**WEST SUSSEX COUNTY COUNCIL
STRATEGIC PLANNING CONSULTATION**

SUBJECT: FP/25/13-Demolition of existing dwelling and erection of new property together with a new single car parking space and carport/ workshop in rear garden.

Fleet Cottage, The Ridgeway, Bognor Regis, West Sussex, PO22 7JQ

Site Plan

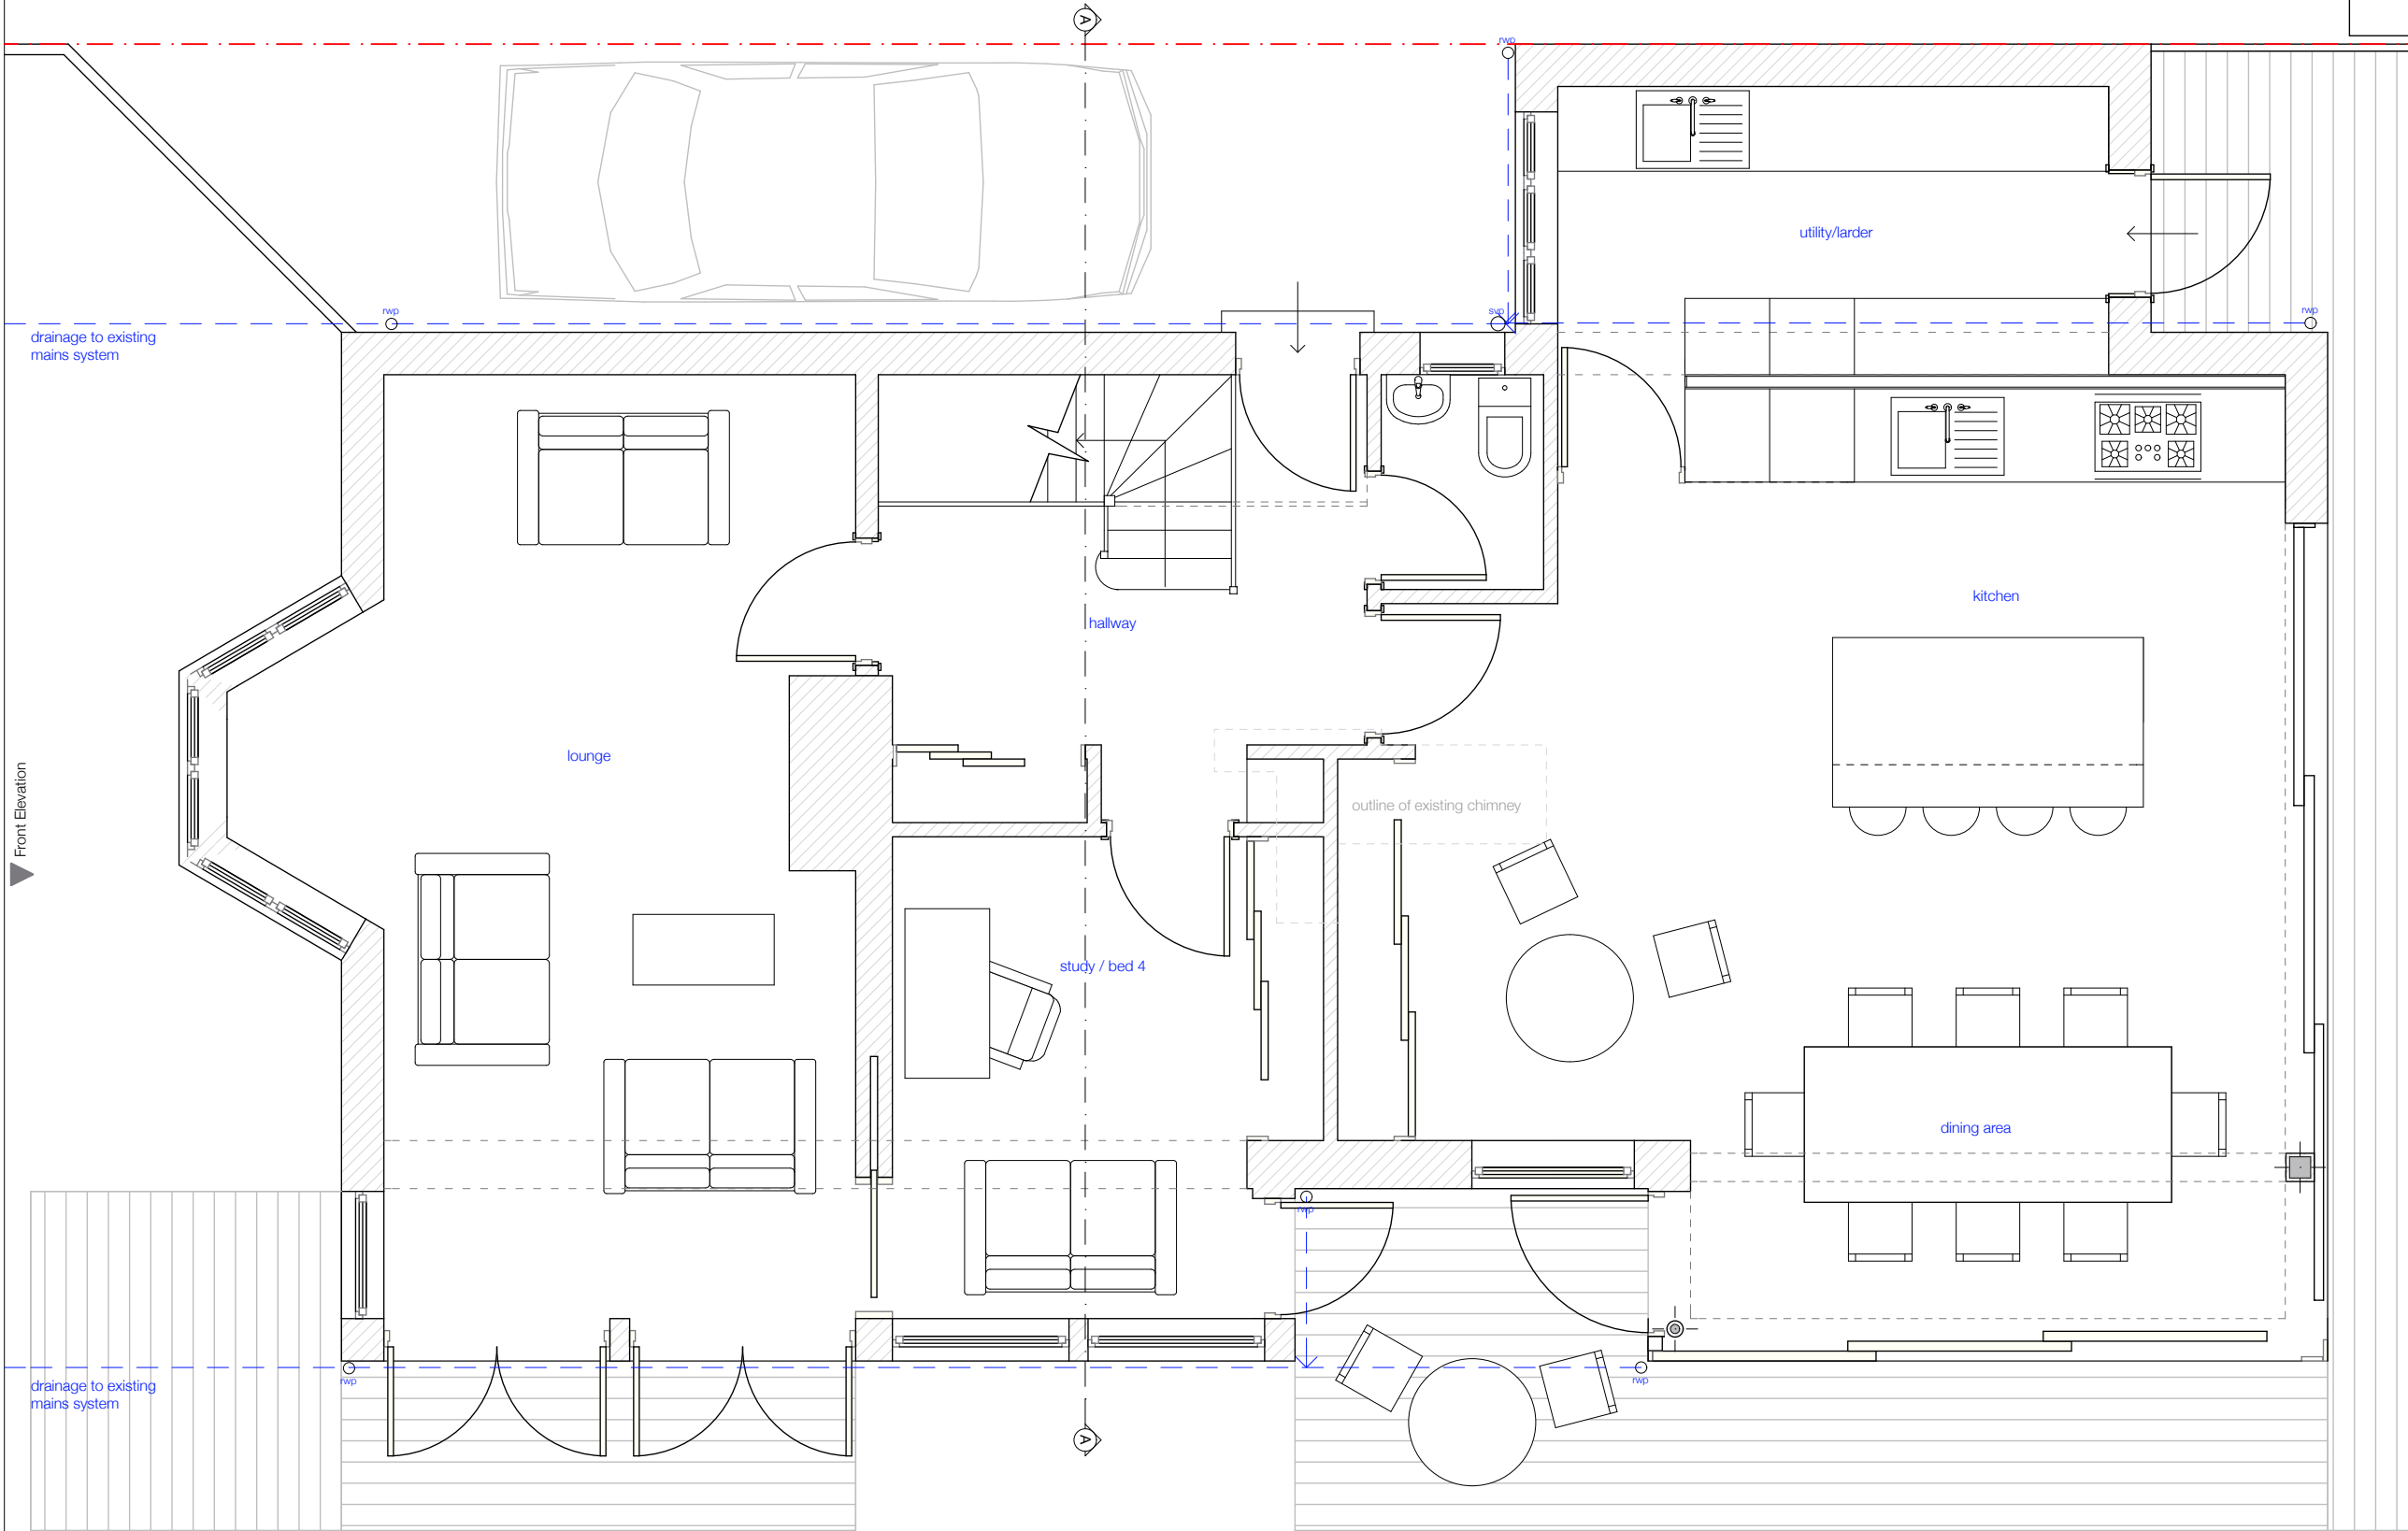
The proposal will be accessed off of a private road not maintained by WSCC. The proposed dwelling is to replace the existing dwelling. Whilst there is a lack of turning within the site, it is acknowledged however that The Ridgeway will be relatively lightly trafficked and that there was previously no parking consequently there would potentially be a decrease in on-street parking. On that basis no concerns would be raised.

In terms of vehicular movements, the proposed dwelling is unlikely to result in any material increase or any detrimental impact.
